Ribble Valley Borough Council  
Housing & Development Control

Your ref: 3/2023/0569  
Our ref: D3.2023.0569  
Date: 14<sup>th</sup> August 2023

Application no: **3/2023/0569**

Address: **Parsonage Farm Church Street Ribchester PR3 3YE**

Location Plan

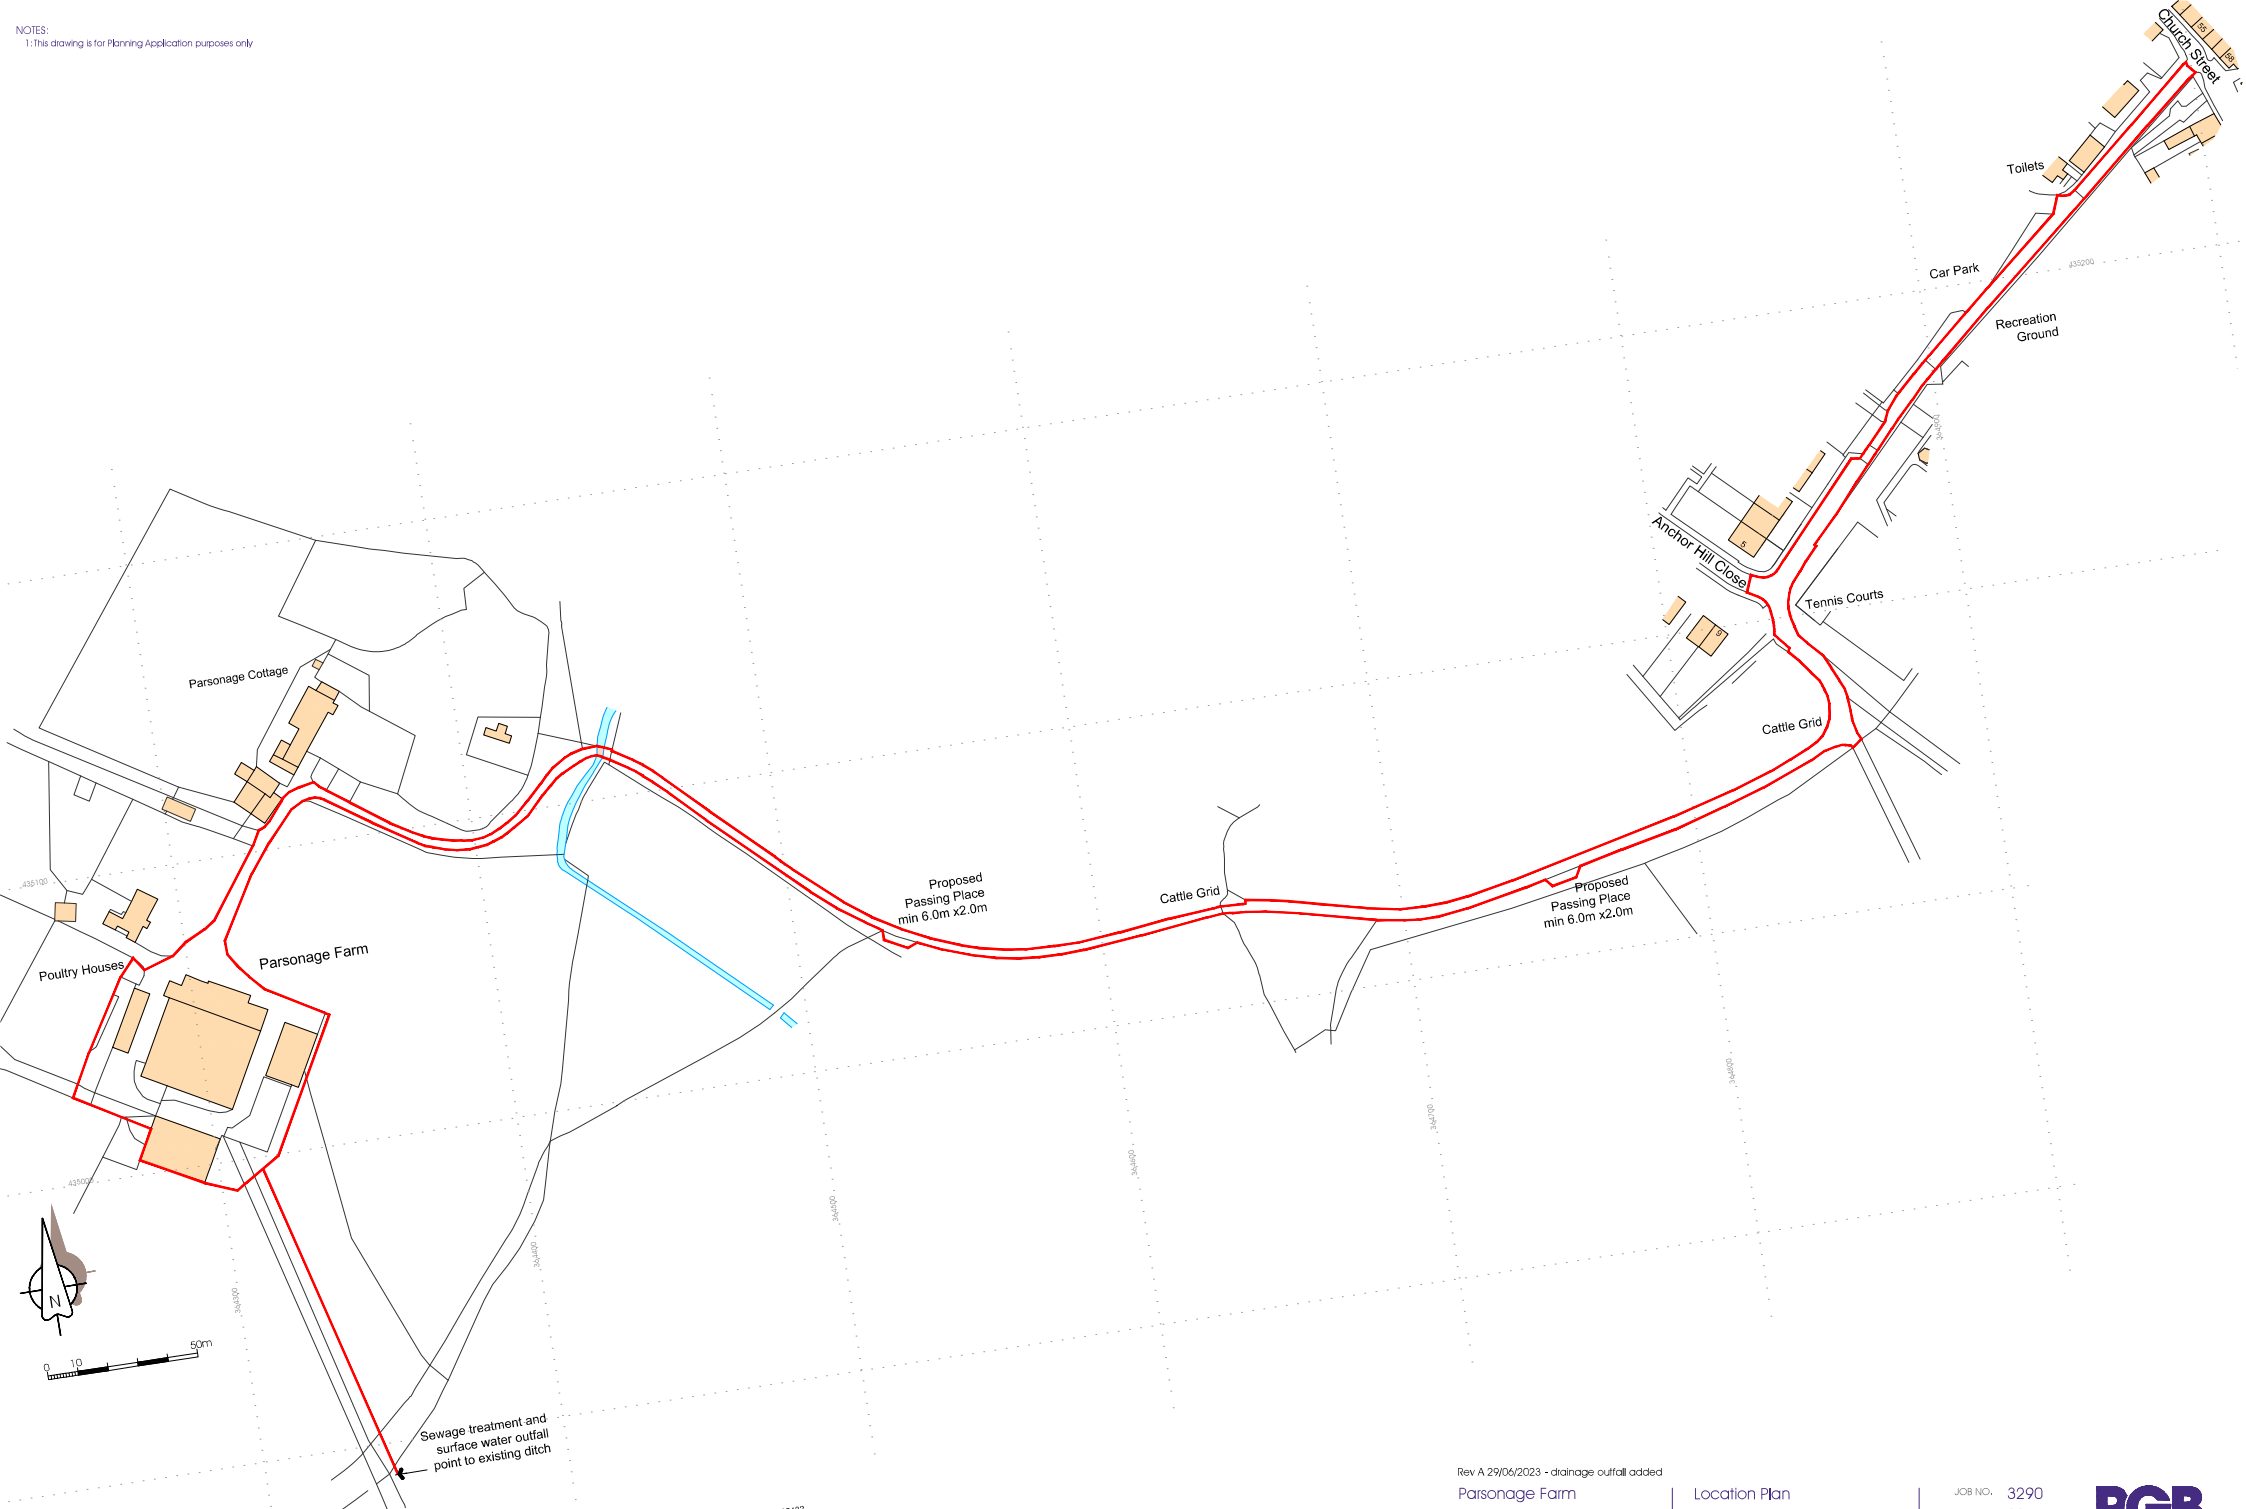
The LHA have reviewed PGB drawing number 001 Rev A titled "Location Plan" and are aware that the Applicant is proposing to erect two passing places along the track, with the dimensions of the passing places being 6m long by 2m wide.

The LHA welcome the introduction of these passing places and have no objection to the proposal. This is because the proposal will take some large, slow moving agricultural vehicles away from the access track and the site will generate similar levels of trips than the proposed, should the farm still be operating. Therefore, the LHA have no objection.

However, the LHA would advise that another passing place is implemented adjacent to the bridge to ensure that two-way movements can occur.

2. No part of the development hereby permitted shall be occupied until such time as the access arrangements shown on PGB drawing number 001 Rev A have been implemented in full.
